Response of the environmental NGOs (eNGOs) to the Secretary of State letter (23 October 2019)

Wylfa Newydd Nuclear Power Station Development Consent Order (EN010007)

Introductory Notes

**VIEWPOINT 25**  
View east from Wales Coast Path at lifeboat monument at Cemlyn Bay

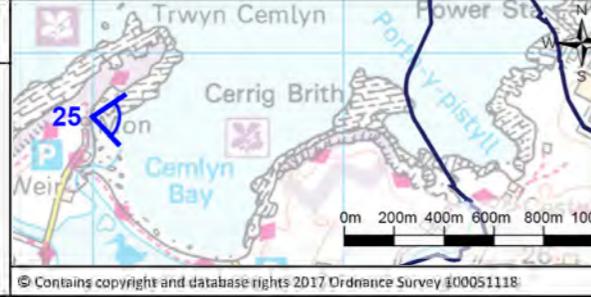
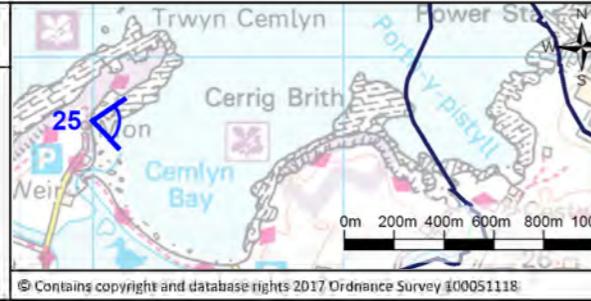
The Applicant has indicated that their position remains the same as that at the end of the Examination (conference call 5 December). This has not addressed the concerns of the eNGOs in respect of the impacts of the works to Mound E in relation to: -

- Visual disturbance on the terns ([REP5-075] ExA2 question Q2.5.8)
- Visual and landscape impacts on the AONB and the visitors to Cemlyn Nature Reserve ([REP2-317] ∞ 3.2)

Whilst some elements of adjustment to the working methods on Mound E have been welcomed by NT, their concluding comment on this matter is a recommended adjustment to the LHMS: -

*“The northern and western faces of Mound E will have regard to the landscape and ecological sensitivity of the adjacent AONB. They will be established in their final form early in the construction period and **will not be reworked**. Early seeding and planting should be delivered with the aim of establishing proposed habitats before the end of the construction period.”*
(emphasis added)

This conclusion was endorsed by NWWT and neither party (NT nor NWWT) accept the justification provided by the Applicant that due to logistics Mound E is the only site within the WNDA which can accommodate materials for later reuse. Given the sensitivity of this construction zone to a multitude of impacts on a variety of receptors (terns, landscape, Cemlyn Lagoon water quality and visitors), the eNGOs contend that alternative solutions should have been considered more fully.
